WELWYN HATFIELD BOROUGH COUNCIL – DEVELOPMENT MANAGEMENT
DELEGATED REPORT

APPLICATION No:	S6/2013/916/FP
APPLICATION Site:	Oshwal Centre, Coppers Lane Road

The application seeks full planning permission for a two storey side extension which in-fills an existing recessed section on the east wall. At the lower ground level this will provide an extension to the lower hall and provide an improved access to an existing external patio area. At the upper level the new floorspace will provide storage space which will serve the main hall area.

EXISTING GROUND FLOOR PLAN

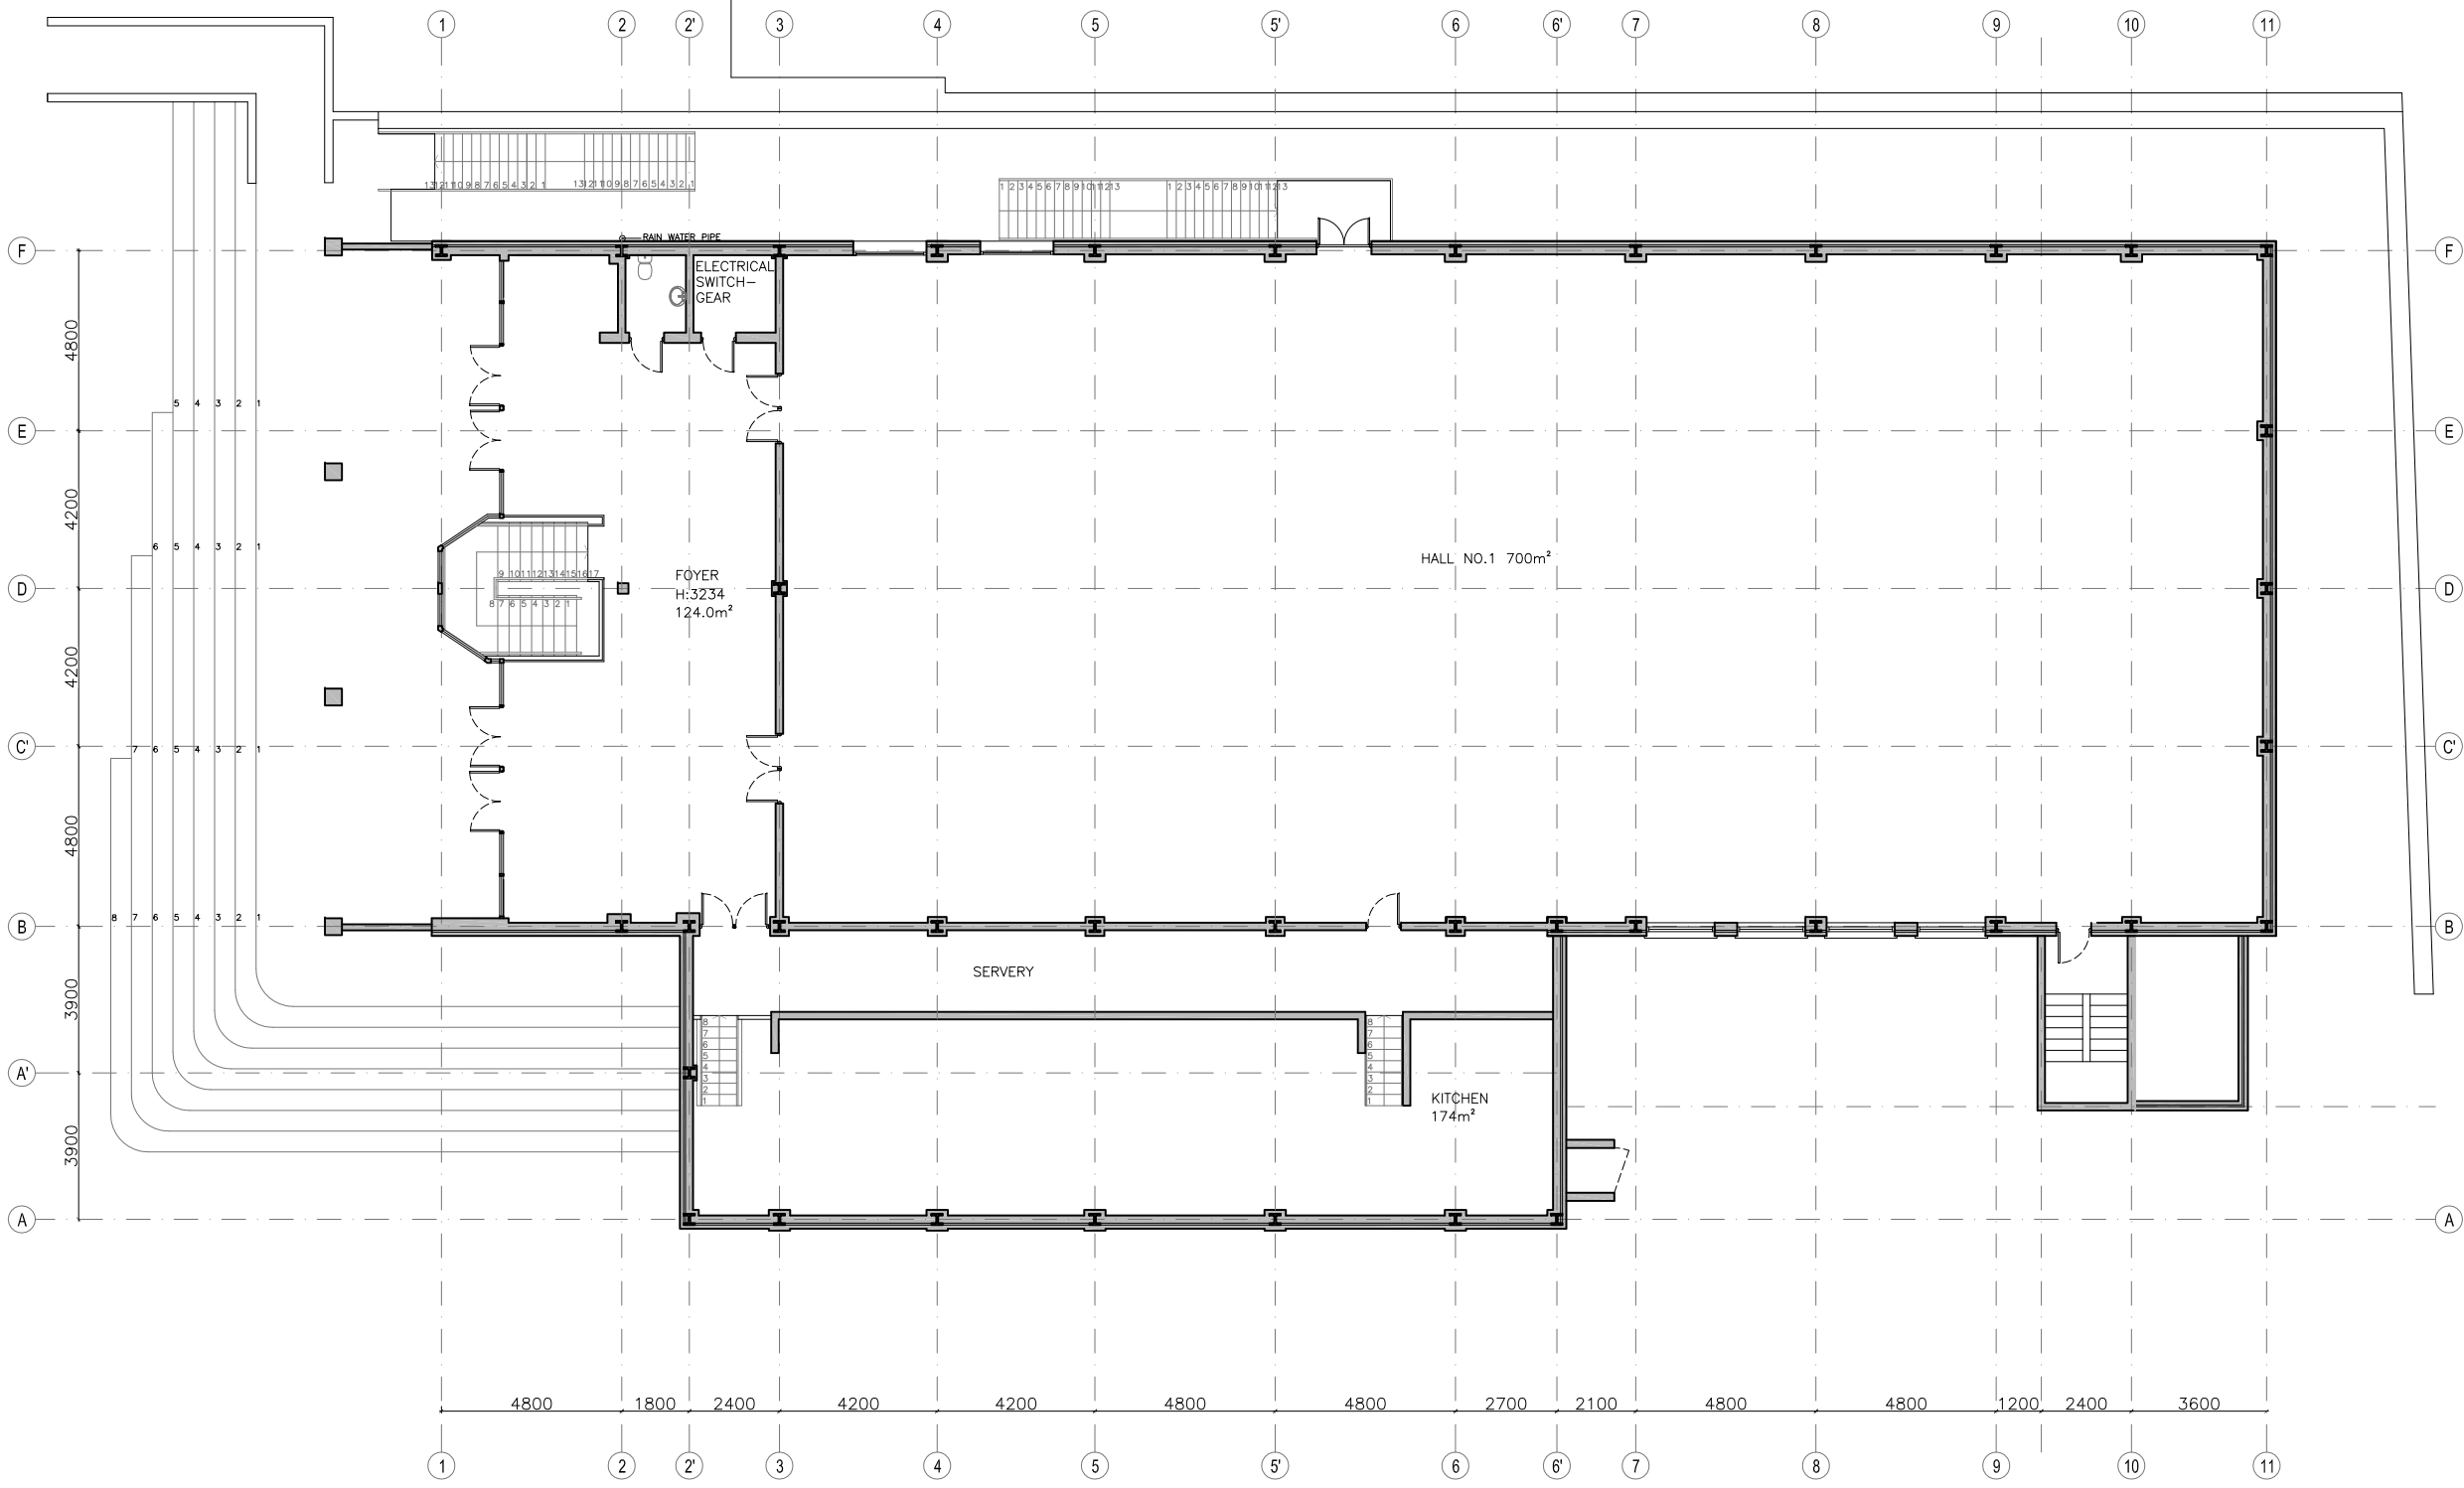
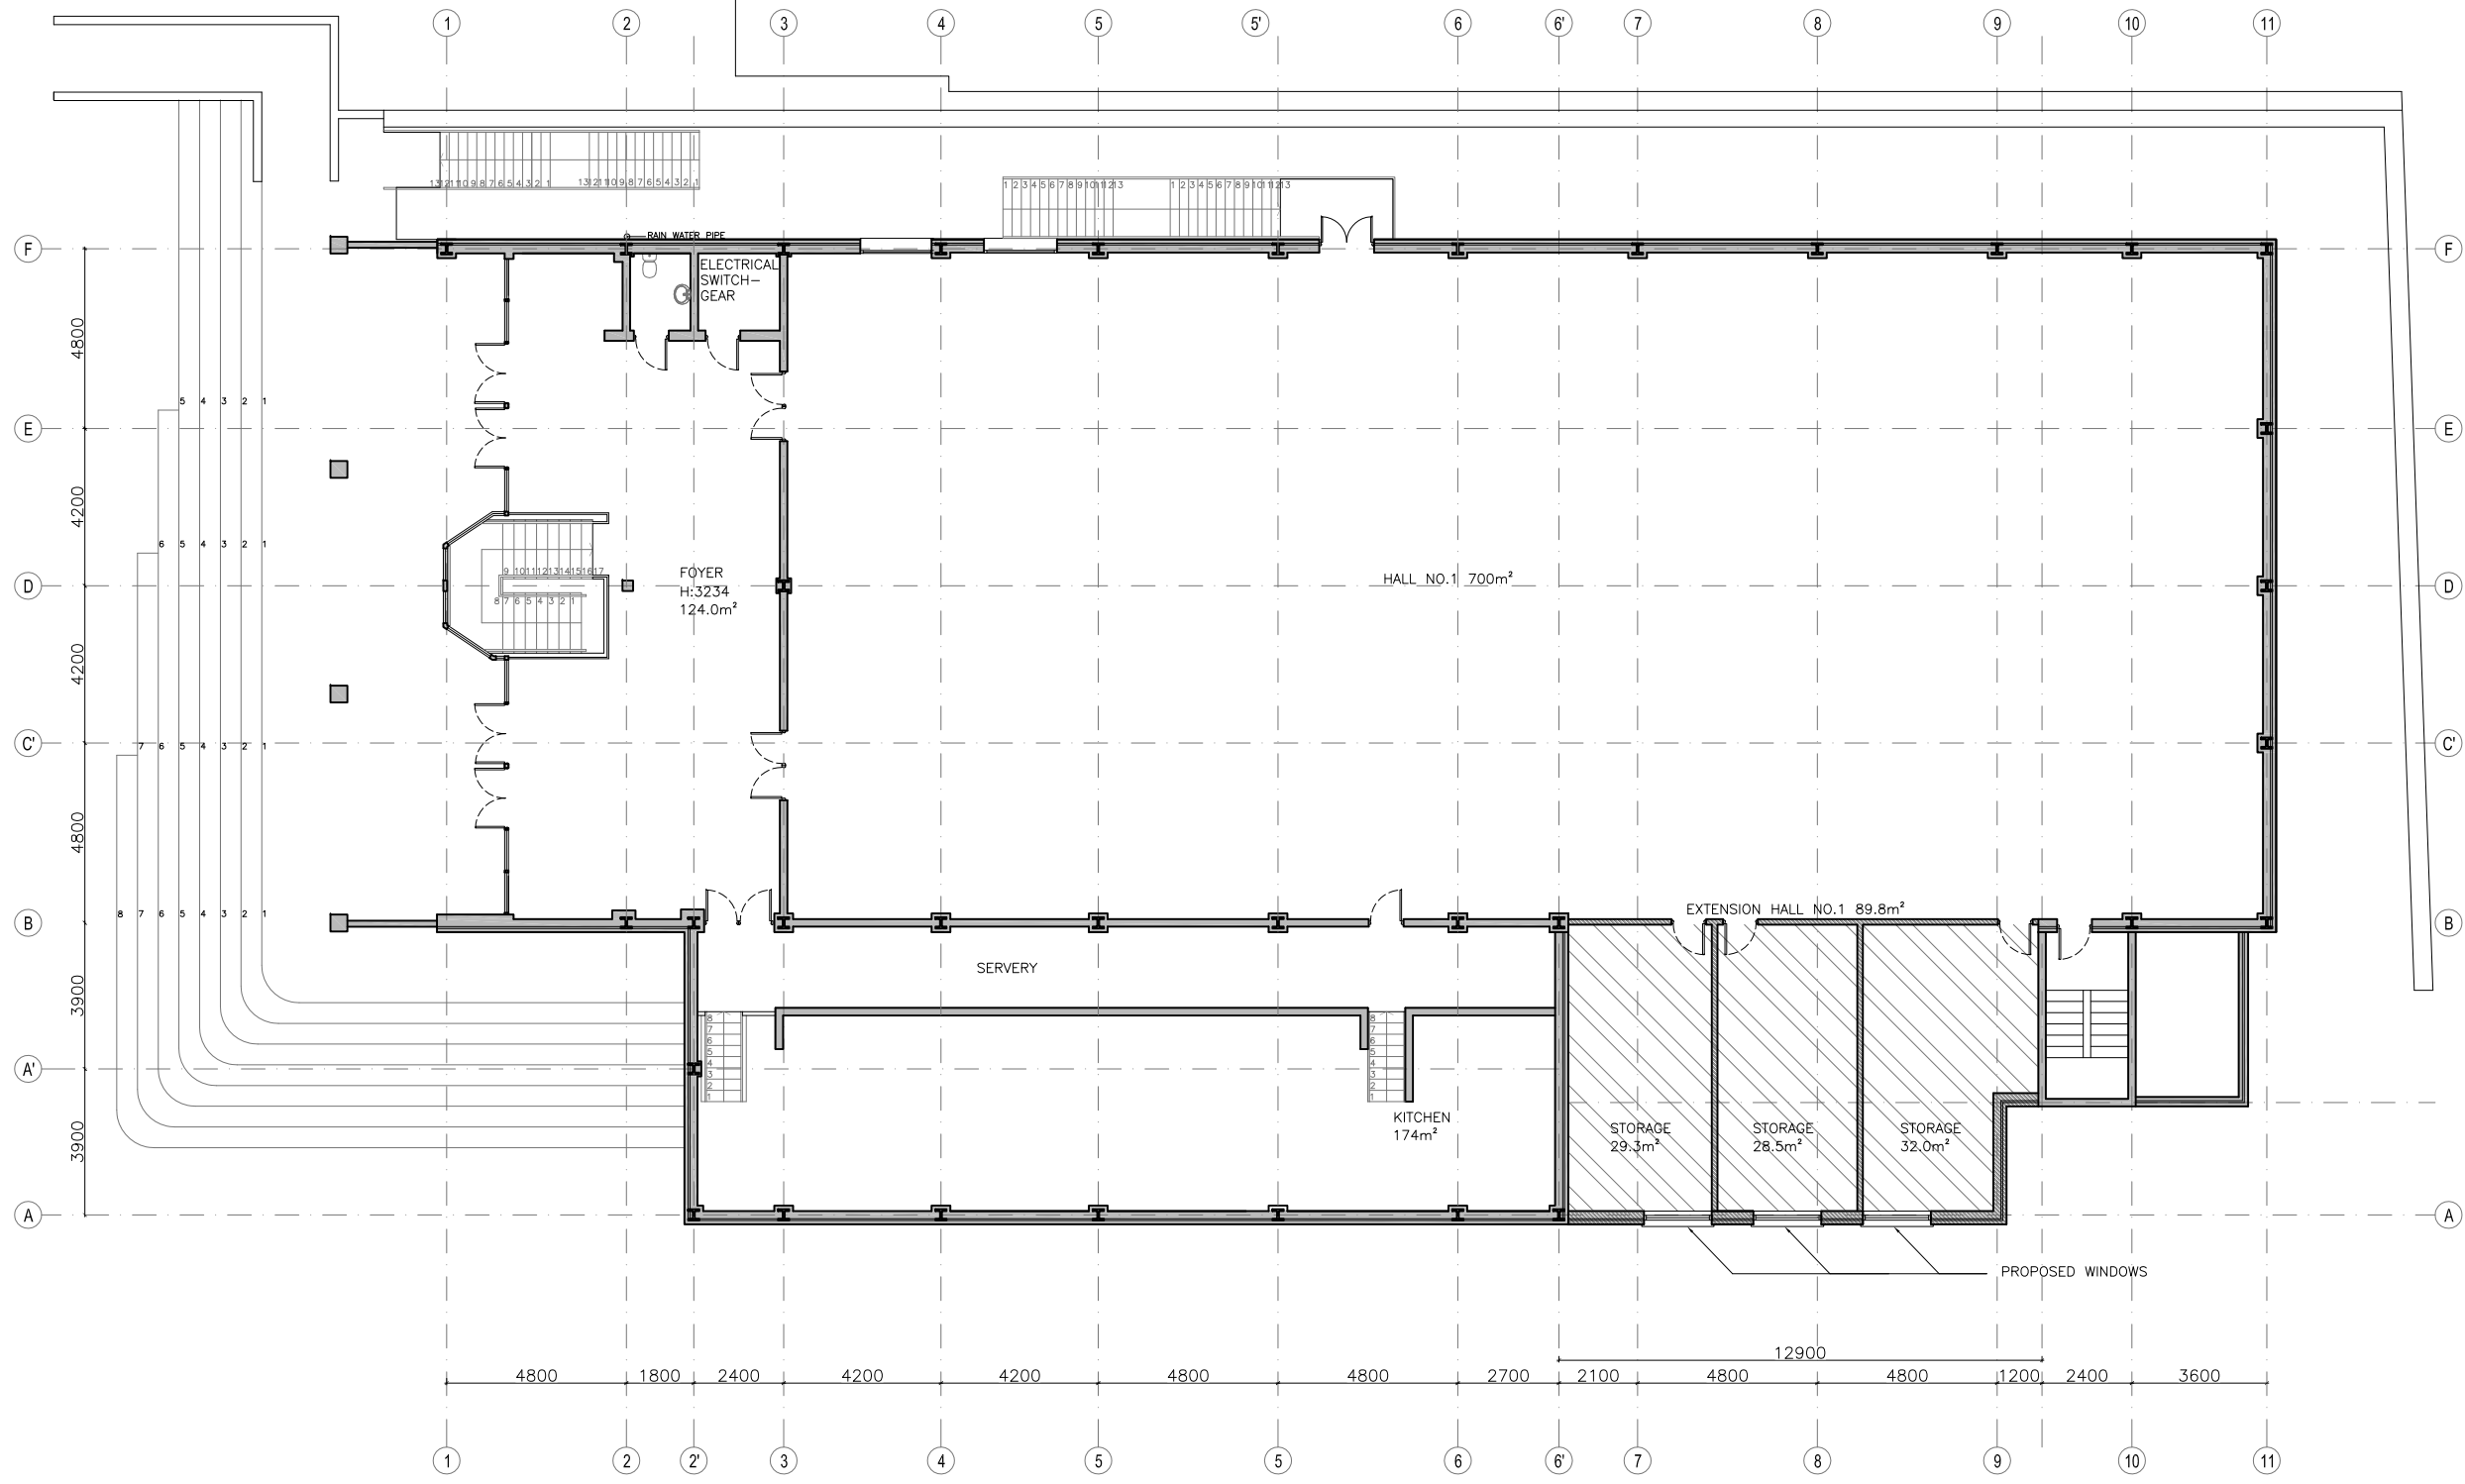
At ground floor level the existing double doors are to be replaced by a total of four double doors to provide better access to the patio for all users.

Disabled Access: Local Plan Policy D9 is relevant. The proposed development will improve access on the ground floor by creating new double doors. As such the proposal is considered to comply with Local Plan Policy D9.
